We object to this development and the reasons for objection are detailed below.

Appendix B to Objection by LCNE Village to Proposed Data Centre at 706 Mowbray Road (SSD-13475973)

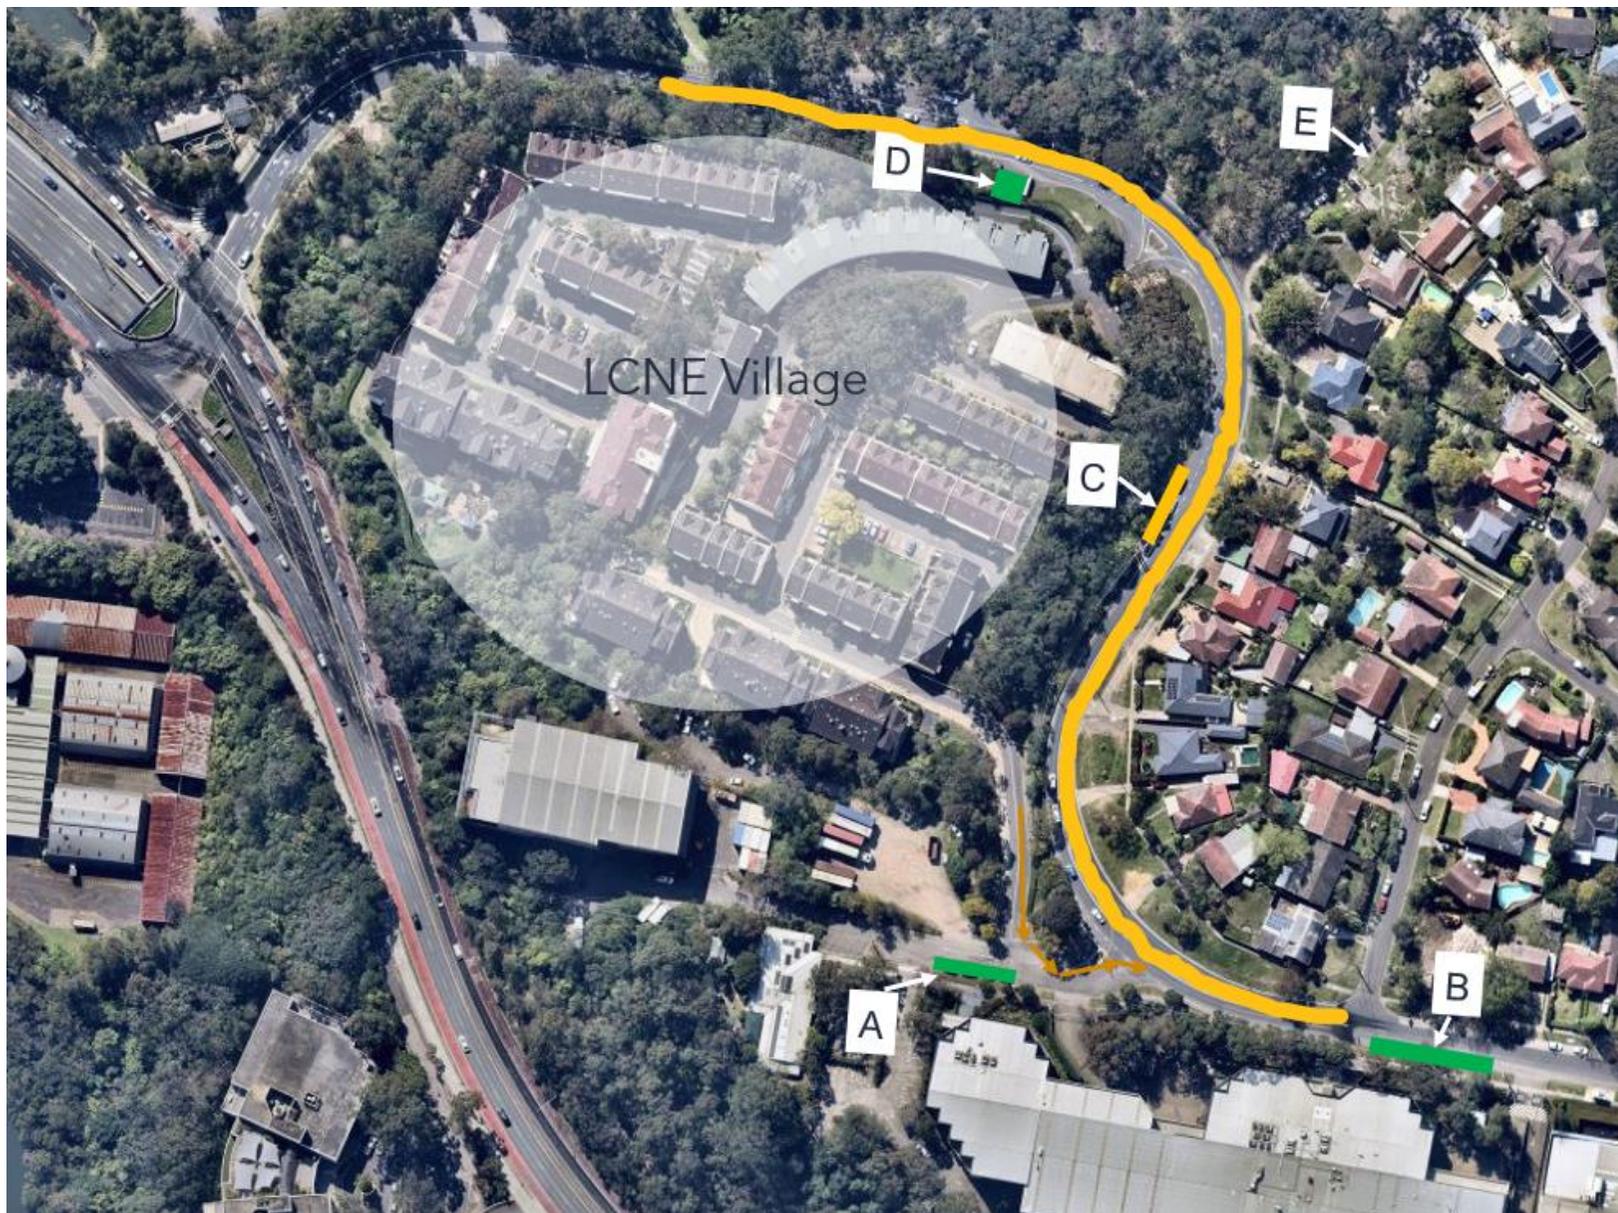
Street parking is already a critical issue in the vicinity of 706 Mowbray Road, as illustrated in Appendix A.

- A constraint that the four unrestricted carparking spots immediately adjacent to the western end of the site be declared as not available for construction purposes, and
- A mechanism to protect the LCNE Village from having workers park their cars in the Village’s visitor carparks.
